Re: 3421028
Herring-Hamilton-C-Lot 3 Griffon Pointe

| Job 3421028 | Truss A05 | Truss Type PORCH TRUSS | Qty 5 | Ply 1 | Herring-Hamilton-C-Lot 3 Griffon Pointe 1 UNIT YF 157068317 |

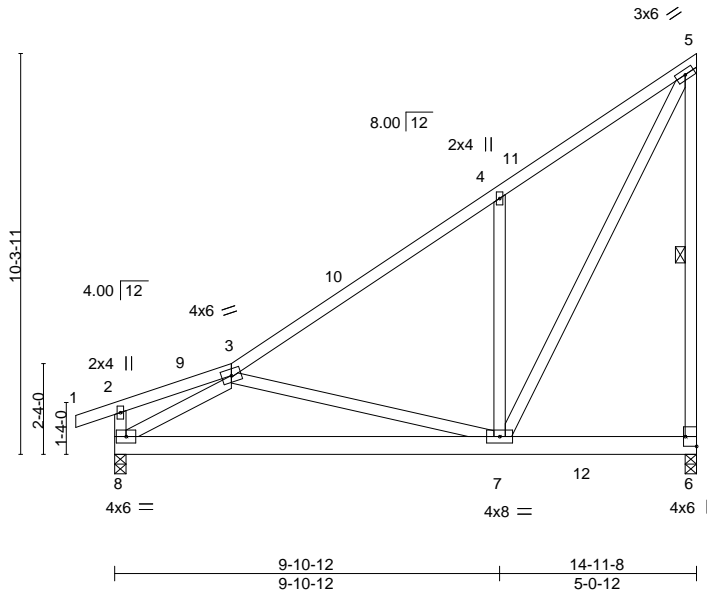
CRACK IN THE MIDDLE OF WEB 5-7

APPLY 2 X 4 X 3' SPF/DF/SP NO.2 SCAB TO ONE FACE OF TRUSS CENTERED ON CRACK. ATTACH WITH (0.131" X 3") NAILS PER THE FOLLOWING NAIL SCHEDULE: 2 ROWS: SPACED @ 2" O.C. USE 2" MEMBER END DISTANCE.
